Please scan as consultative response for AB/49/17/L

GROUND FLOOR PROPOSAL

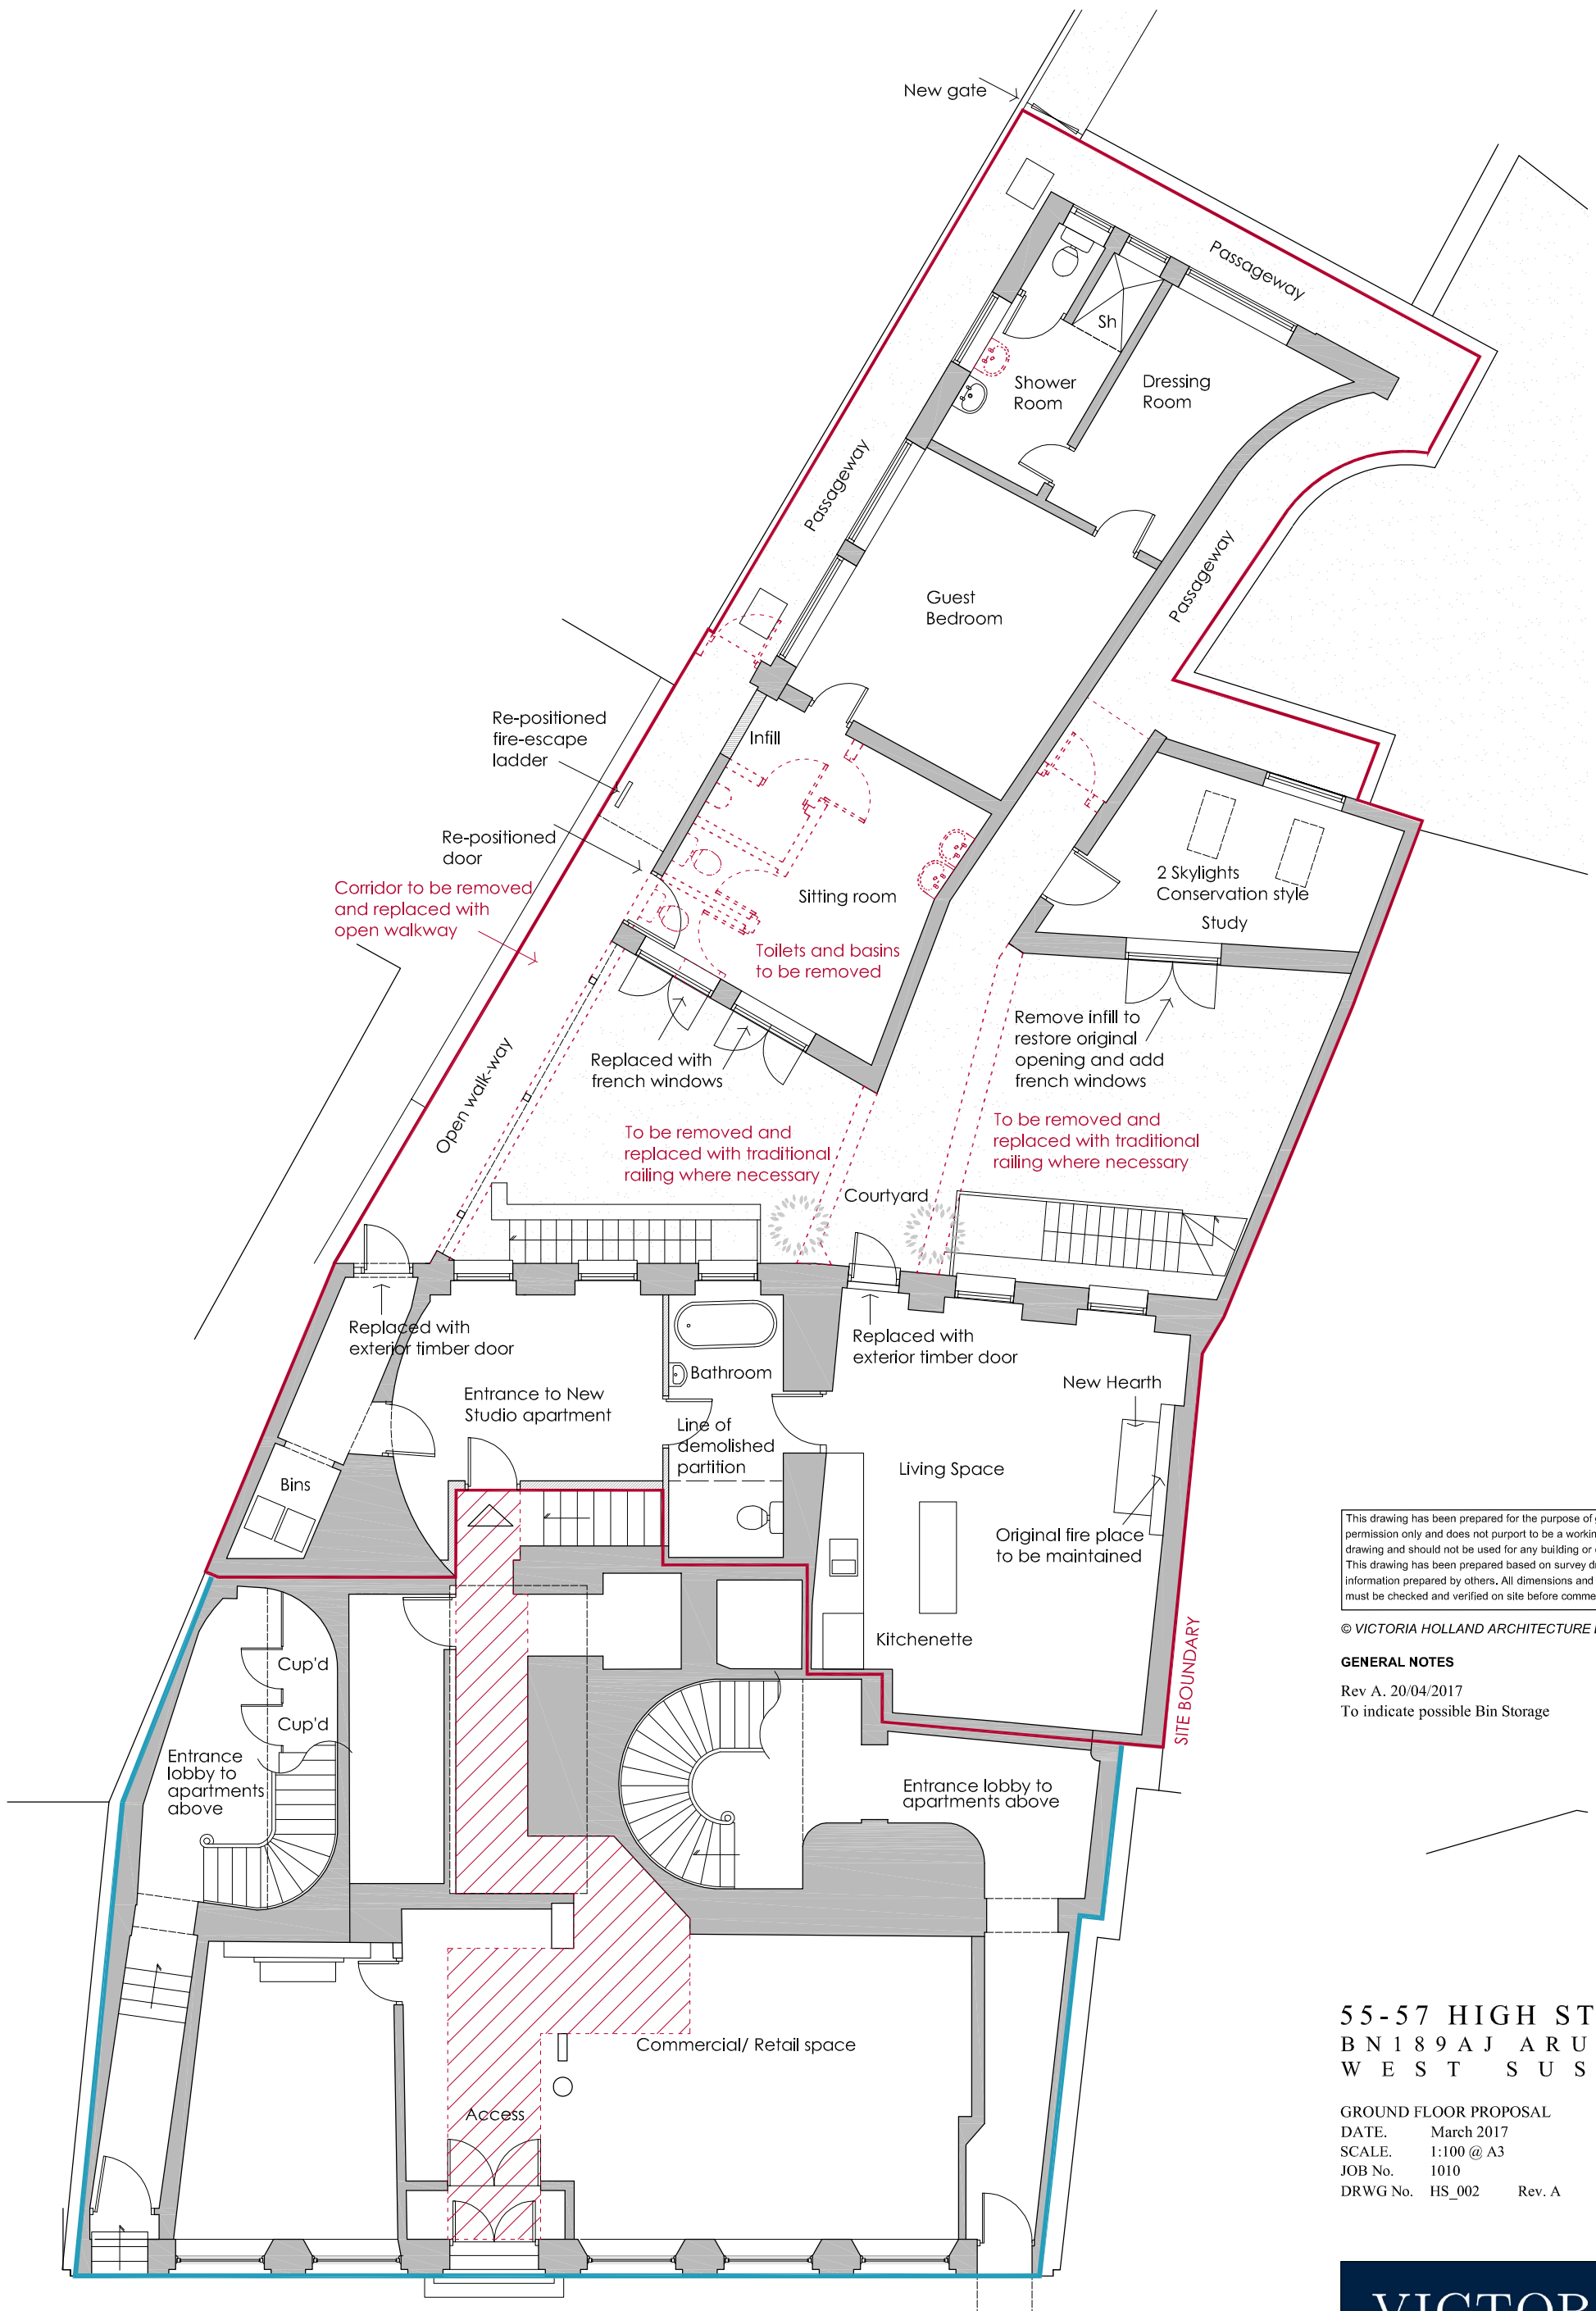
This appears fine generally.
I don't like the new internal
partitions especially, but there
are a lot of positives.
Please condition doors/windows
as usual. Thanks
